20 Sandpiper Road, Permit Application 2016-02999

Thank you for your comments regarding our project on 20 Sandpiper Road.

S1
Proposed
Roof
Framing Plan

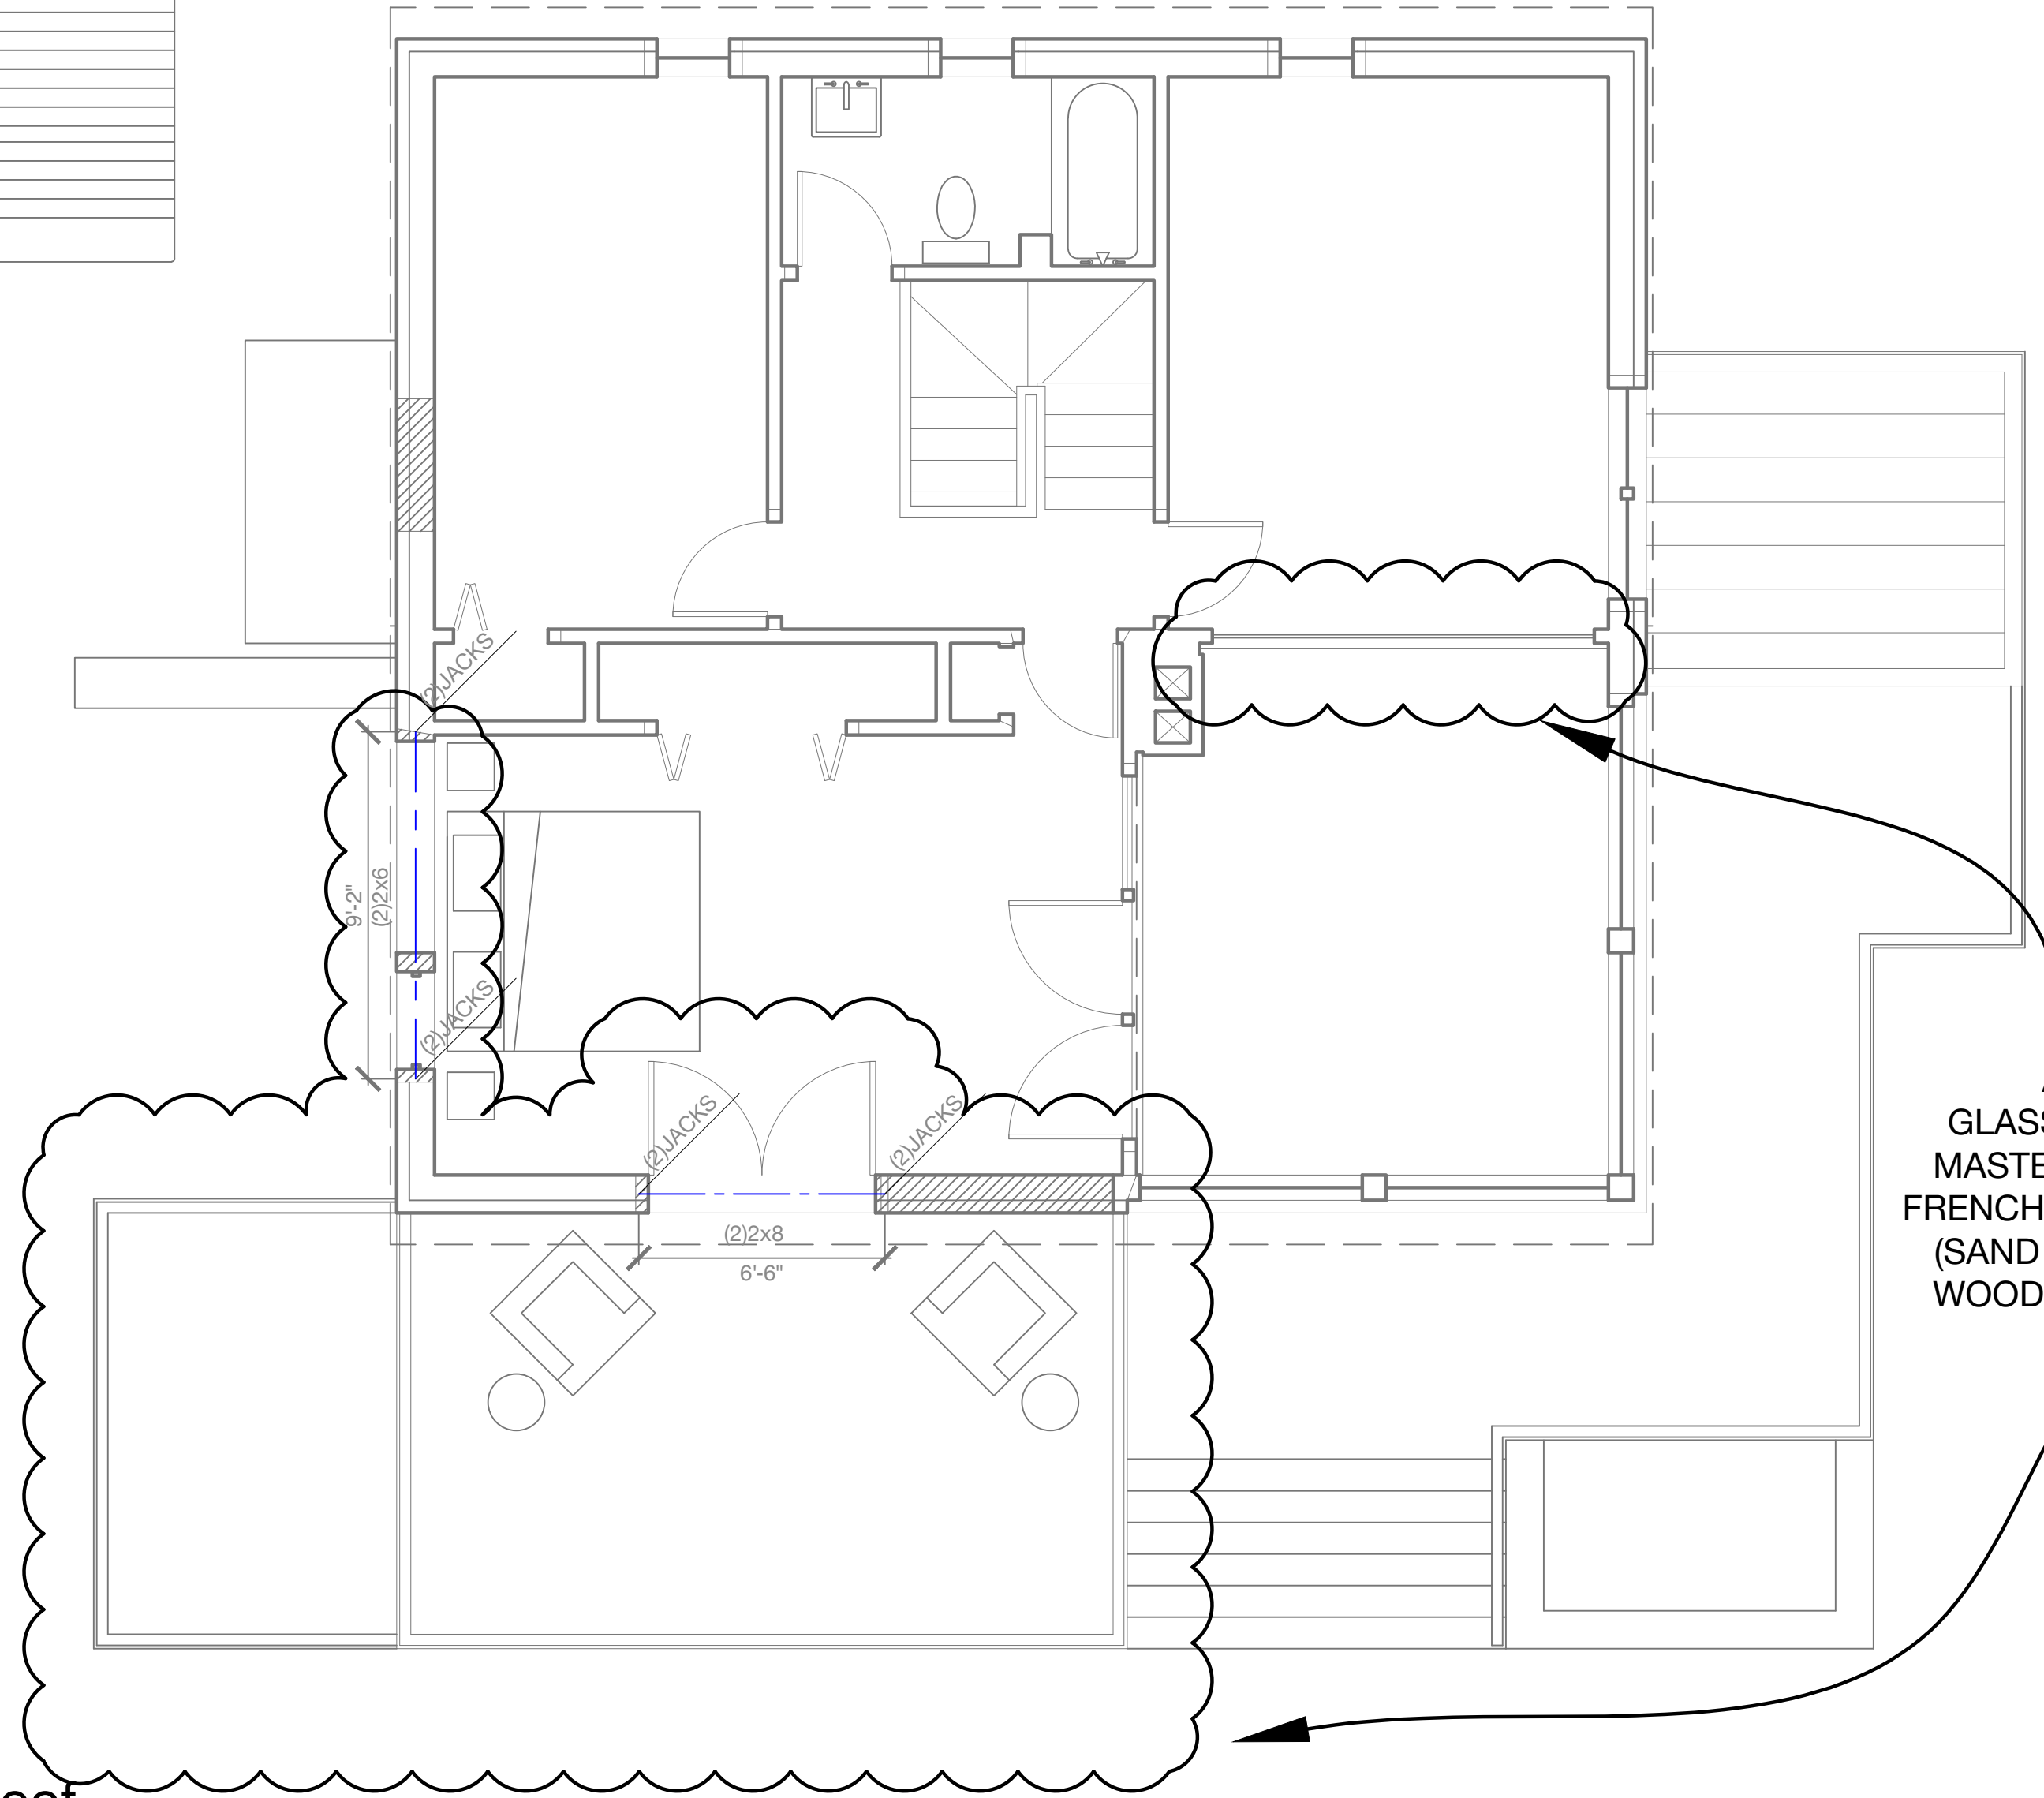
Page S1

Regarding the header size for door, again please note the framing was specified and stamped by a Andy Jackson, PE.
